Application No: R/90/22/HH
Site Address: Kingfishers 10 Fosters Close Rustington BN16 2TL
Description of works: Single storey side garage extension, front porch extension, hip to gable loft conversion including the installation of front dormers and rooflights and alterations to fenestration/openings.

Thank you for your internet representation made on 14th May 2022 which has been recorded as an objection with the comments as follows:

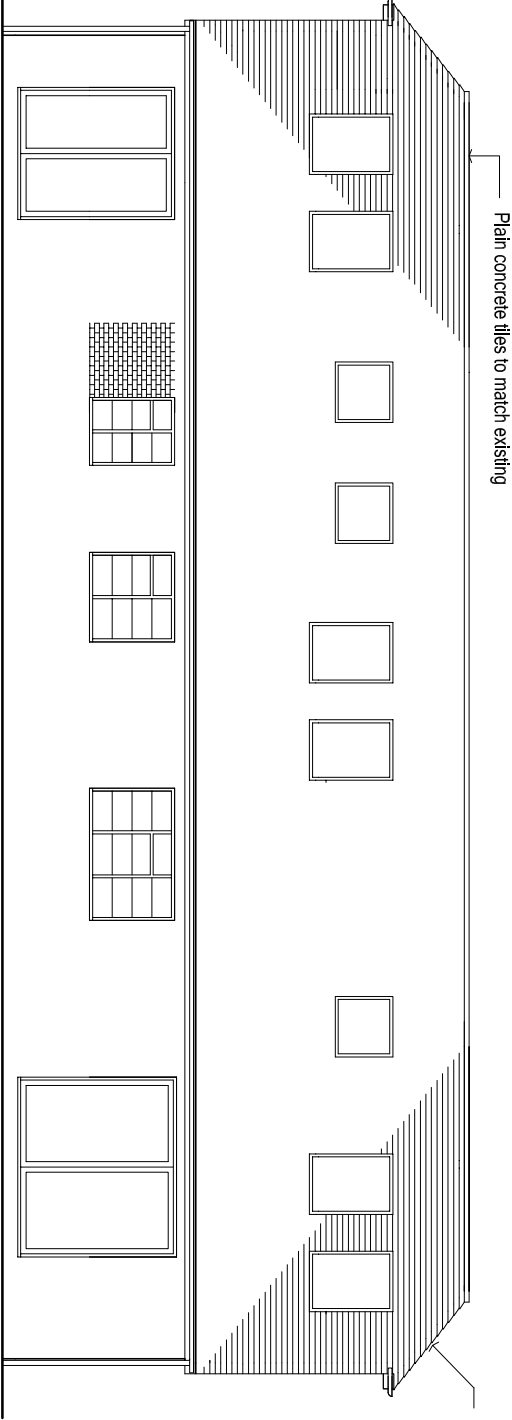
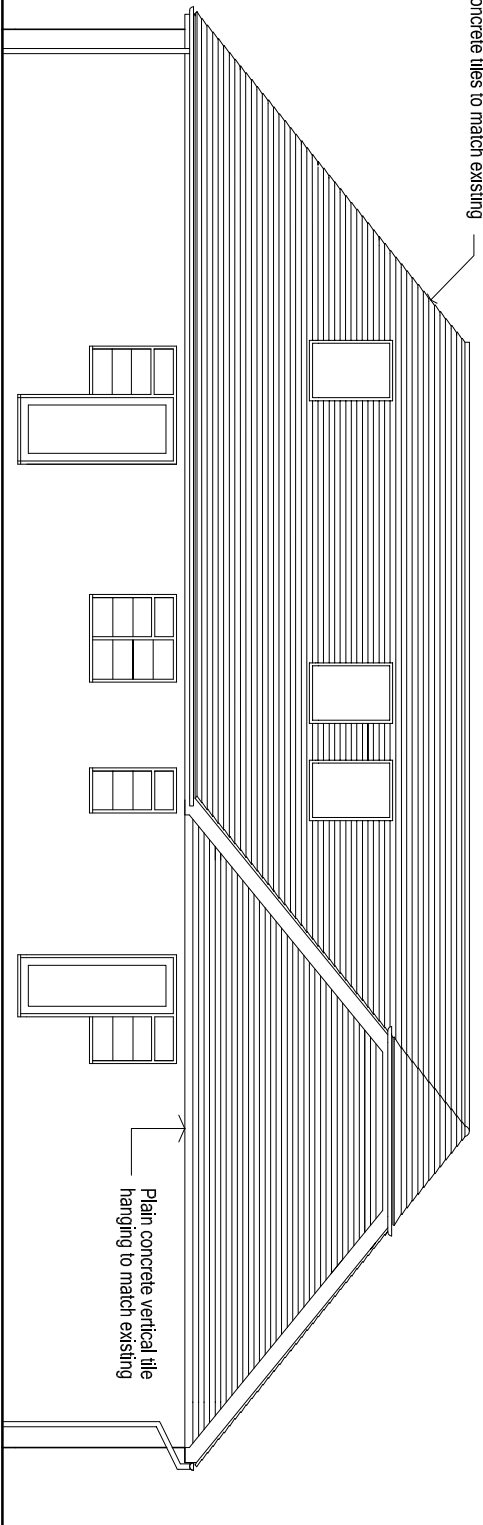
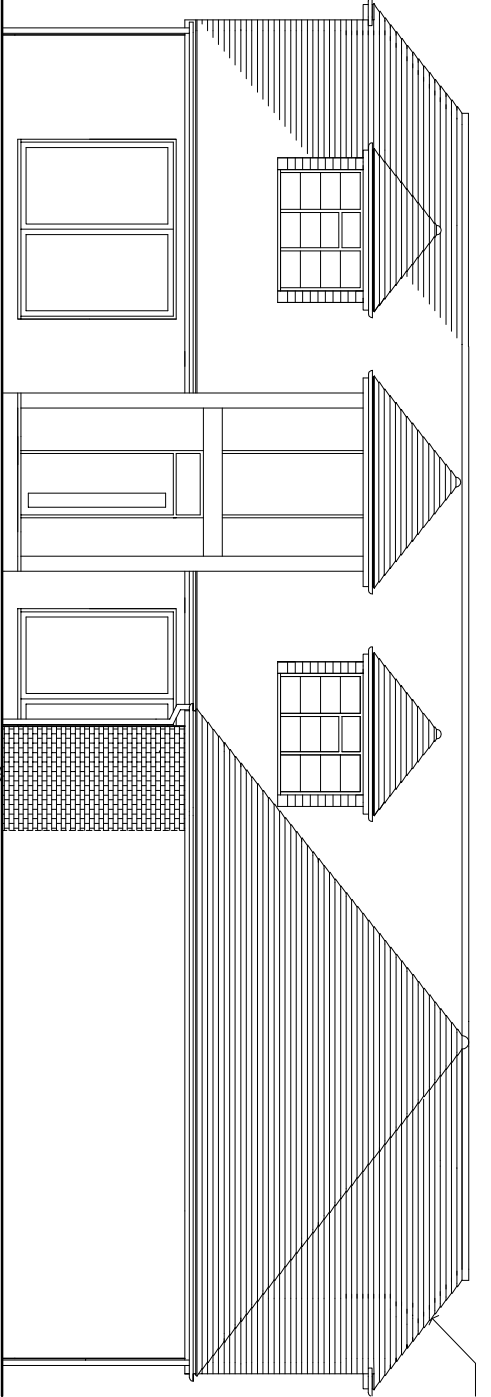
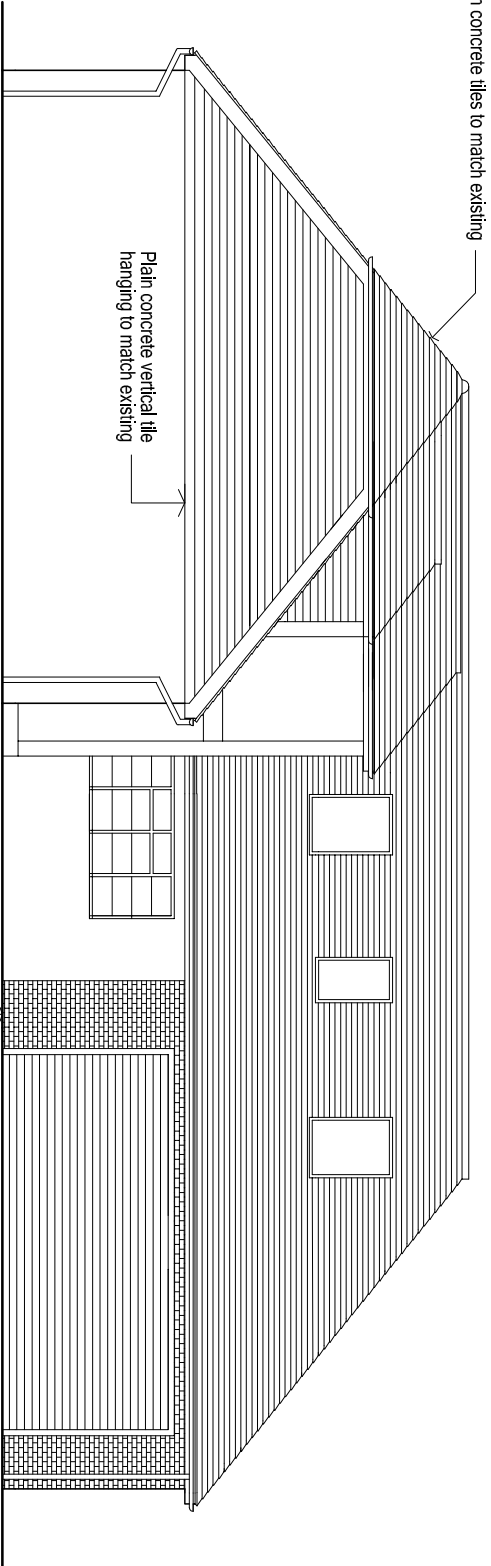
I strongly oppose the planning application of the development of 10 Fosters close. The proposed dormers and front door elevation will directly overlook our properties front elevation which includes our entire frontage. The proposed elevation is appoxamatly 20 metres from our bungalow. This will reduce our privacy dramatically and is a complete over development for the size of property and footprint.
